Appendix B: Agency Advice Response

Figure 94 - Stage 1 Upper Floor Plan (yellow & pink shaded refuge areas)

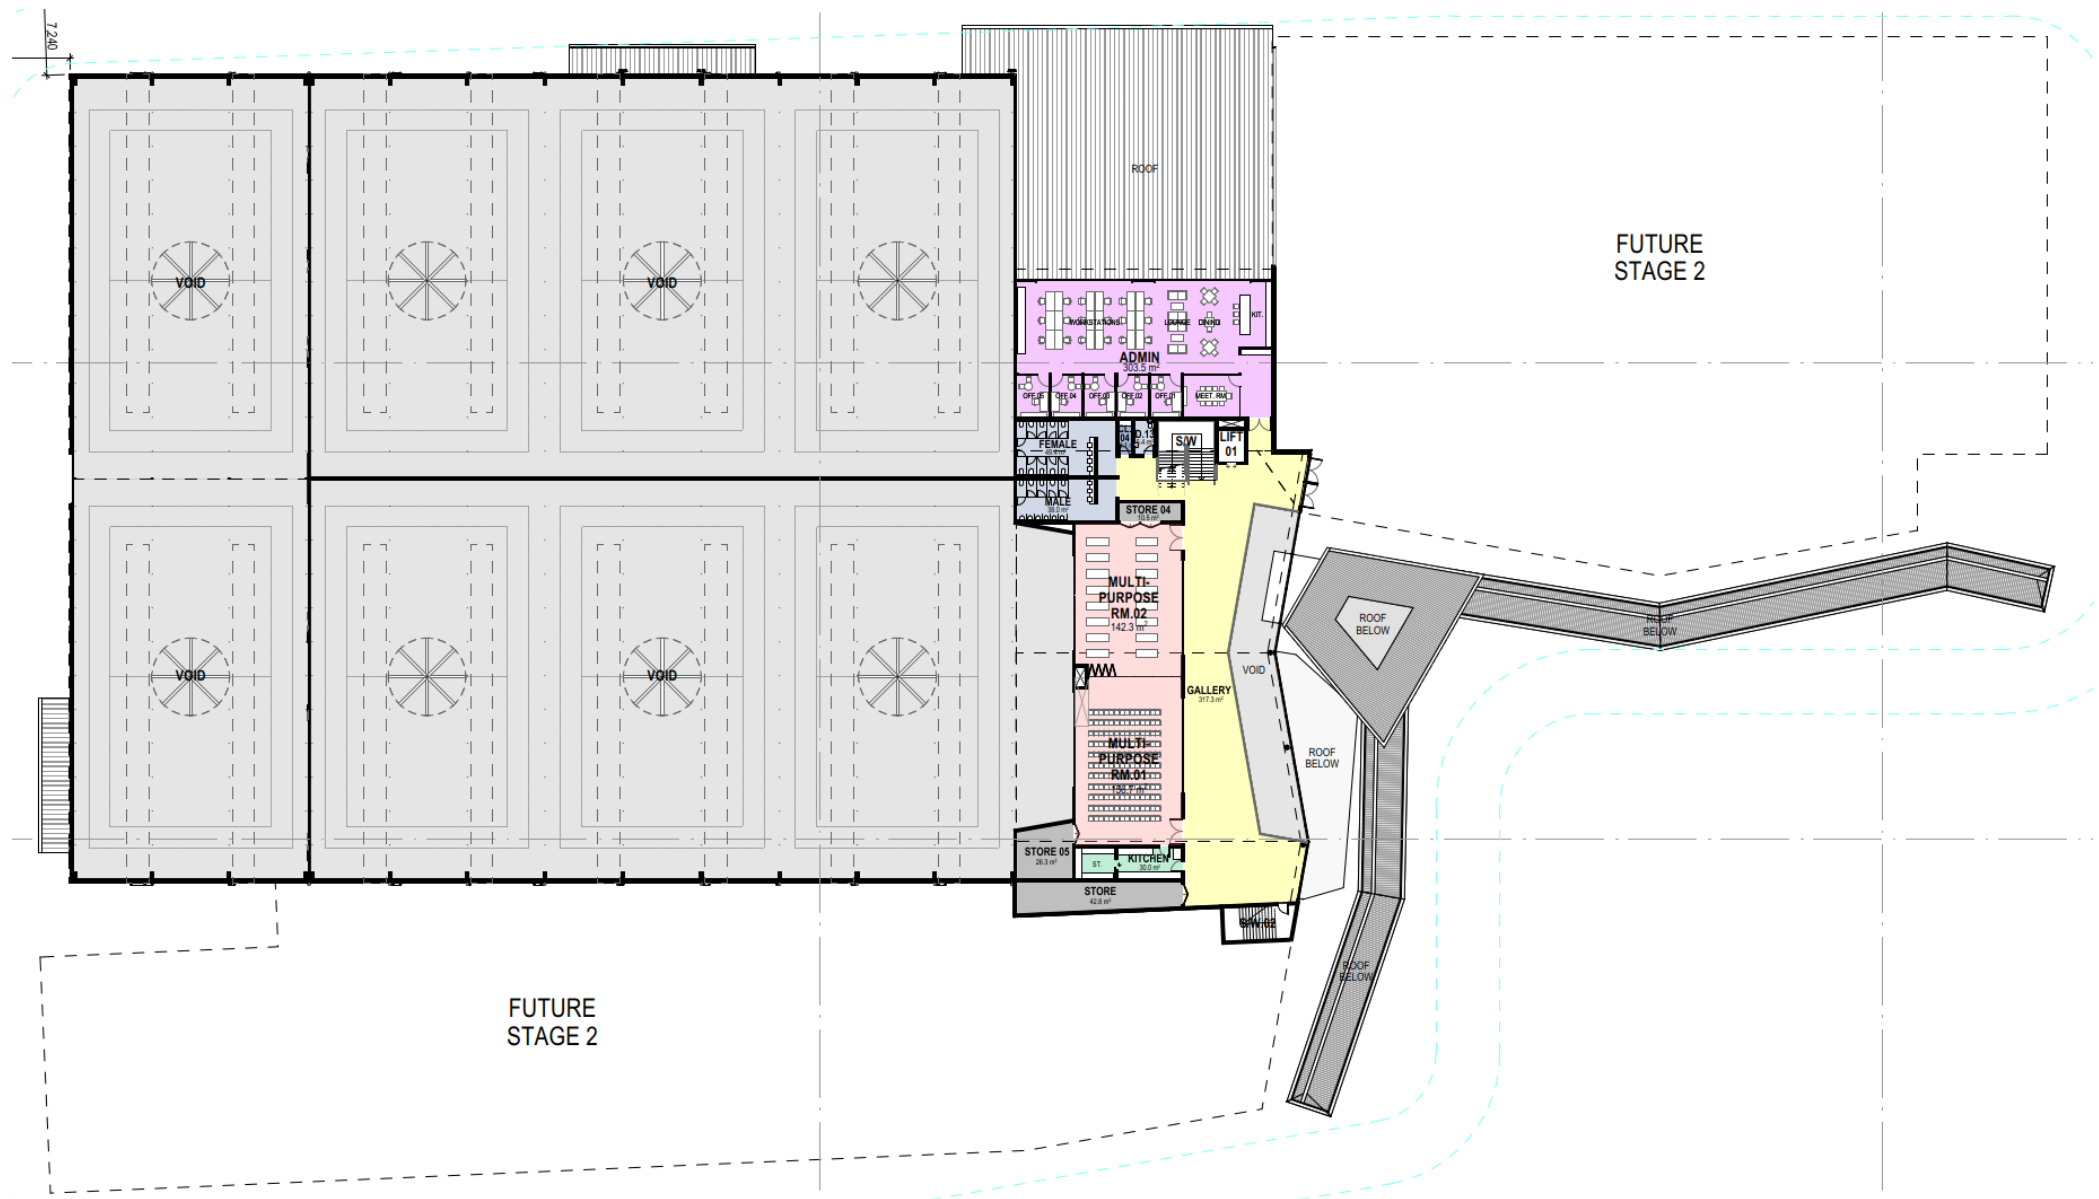
Category of Issue	Issue(s) Raised	Response/ Action
	<i>In some cases, content from submissions has been abridged or edited for brevity.</i>	
	The FERP must also make clear provision for patrons with disabilities including a solution for wheelchair users. Provide an updated FERP.	An evacuation chair will be available at each of the stair wells within the building to assist site management in the relocation of physically impaired patrons to the upstairs flood refuge area. Reference to this has been added to the end of Section 4.1.2 in the FERP.
	The applicant must consult with the NSW State Emergency Service when preparing the amended FERP. Provide details of any consultation, including feedback.	<p>The project team including Torrent met with SES on 11 November 2025.</p> <p>The purpose of the meeting was to review and discuss the SES advice letter issued in respect of the RTS and Amended Project Report.</p> <p>The discussion included consideration of whether alternative access to the HISC (ie from Womboin) had been considered. A significant amount of consultation was taken concerning the proposed site access with Council and TfNSW agreeing that site access from Turton Road was preferable to locating this off Womboin, a residential road.</p> <p>The engagement with SES informed updates to the FERP eg there were concerns raised from SES about responders wading through floodwaters and this reference has been removed. The updated FERP clarifies the circumstances when the site will be closed due to flooding, confirming the low risk of patrons being on site in a flood event. The FERP also goes into detail to demonstrate that the project provides adequate space to comply with shelter in place guidelines.</p>
